GG119 ROAD SAFETY AUDIT RESPONSE REPORT

Project Title:	Denby Lane, Grange Moor
Project Team:	Via Solutions
RSA Report Stage:	1
RSA Organisation:	Sevenairs Consulting Ltd
RSA Report Reference:	2024-12 Grange Moor RSA1 - Rev 0
RSA Report Issue Date:	December 2024
Report Title:	RSA Response Report
Reference:	23102 Grange Moor RSA RR

This Road Safety Audit Response Report relates to a Stage 1 Road Safety Audit carried out on a proposed access from Denby Lane which will serve 11 dwellings (Planning Application Reference 2023/93704). The scheme is for a simple priority junction and a new footway along Denby Lane.

1 Proposed Site Layout

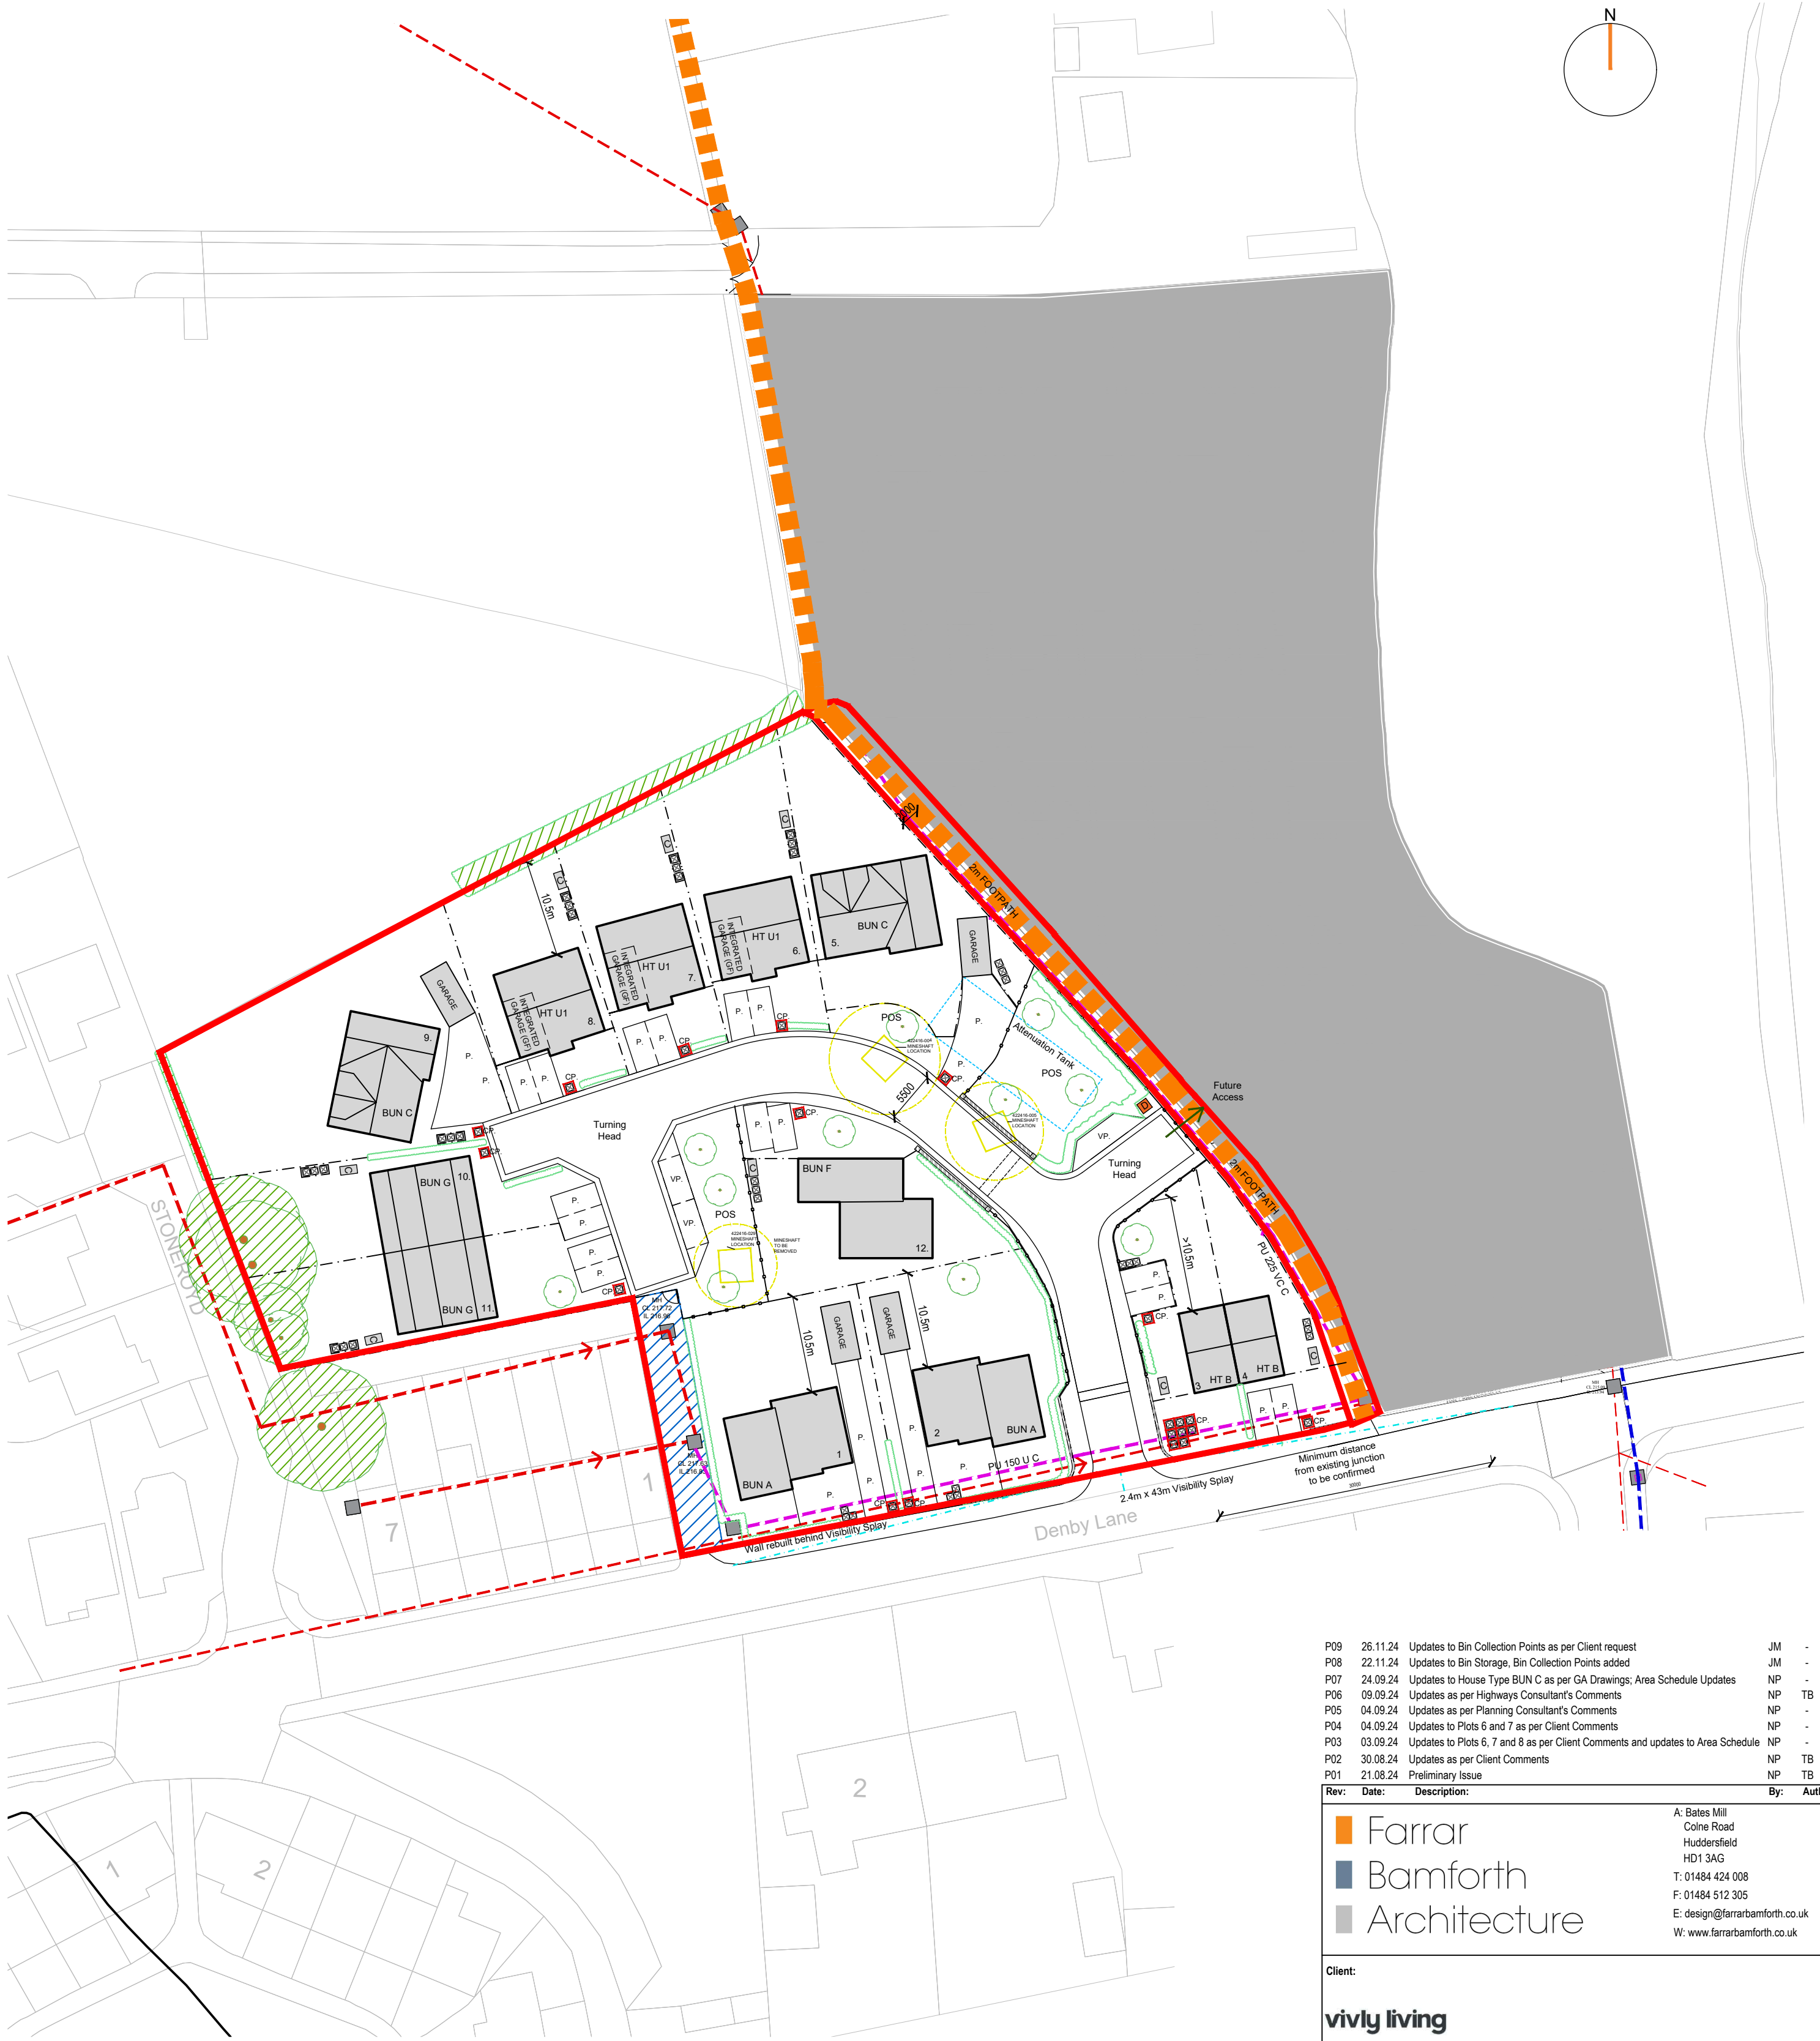
<p><u>Road Safety Audit Problem and Recommendation</u></p> <p>Problem A-01</p> <p>Location: <i>Denby Lane and along the development road.</i></p> <p>Summary: <i>Drainage – Insufficient surface water drainage may increase the risk of skidding type collisions as well as slips and falls by pedestrians and cyclists.</i></p> <p>Detail: At this early stage, no details have been provided on the proposed drainage arrangements. The proposals indicate what appear to be ramps onto shared space areas and the site appears to generally grade down from the main carriageway. As such, this may require measures to manage surface water around the ramps and into the development that could, if left unmanaged, increase the risk of skidding type collisions on the development road. There may also be the potential for standing water and detritus in low areas which may increase the risk of slips and falls by pedestrians using the development road and, in particular, the shared space area.</p> <p>Recommendation: It is recommended that all low areas are provided with suitable measures to minimise the risk of standing water and detritus.</p>

<p><u>Design Team Response</u></p> <p>Not accepted. The design does include a level interface into the shared area, with a proceeding ramp on the carriageway as per Kirklees Design Guide requirements.</p>
<p><u>Overseeing Organisation Response</u></p> <p>Agree with RSA problem and recommendation, do not fully agree with Design team response, no information is shown to indicate the transition from footway to shared surface area.</p>
<p><u>Post-RSA Action</u></p> <p>Suitable transition to be incorporated at detailed design stage in line with Kirklees Councils standard detail: Junction / pavement and kerb layout with tie in detail (dwg ref HD-SD-07-15A).</p>

Detail: At this early stage, details around kerbs will not have been considered. However, there appears to be a lack of footpath provision between the shared space and the homes leaving users to use the driveways to access properties. Typically, a higher 25mm dropped kerb is provided for driveways which makes access difficult for pedestrians with mobility issues specifically those users with prams, wheelchairs or mobility scooters. This may result in these users being trapped in the shared use areas unable to access homes on the development and may increase the risk of these users being involved in collisions with other road users. The lack of dropped crossings for access to homes may increase the risk of collisions involving users with mobility issues.

Recommendation: It is recommended that flush kerbs are provided to facilitate access by users who rely on mobility aids to homes, private driveways and other shared parking areas.

<p><u>Design Team Response</u></p> <p>Accepted, to be considered as part of the S38 process.</p>
<p><u>Overseeing Organisation Response</u></p> <p>Agree with RSA problem and recommendation and design team response.</p>
<p><u>Post-RSA Action</u></p> <p>Suitable drainage to be incorporated at detailed design stage.</p>
<p><u>Road Safety Audit Problem and Recommendation</u></p> <p>Problem A02</p> <p>Location: <i>Denby Lane – At the development access.</i></p> <p>Summary: <i>Specific Road Users – Lack of interface between footpaths and a shared surface area may increase the risk of collisions involving wheelchairs, mobility scooters and pushchairs.</i></p> <p>Detail: The development road appears to be a shared space area. It is unclear how the interface between this area and the footway on the main road fronting the development provides for users of wheelchairs, mobility scooters and pushchairs to safely transition between the shared space and existing footways. It appears to require these users to drop into the carriageway junction mouth and then into the shared space area directly. This lack of interface between footpaths and a shared space area may increase the risk of collisions involving wheelchairs, mobility scooters and pushchairs.</p> <p>Recommendation: It is recommended that a level interface transition is provided at the interface between formal footways the shared space area.</p>

Accepted, to be considered as part of the S38 process.

Agree with RSA problem and recommendation and design team response.

Suitable pedestrian dropped crossing to be incorporated at detailed design stage.
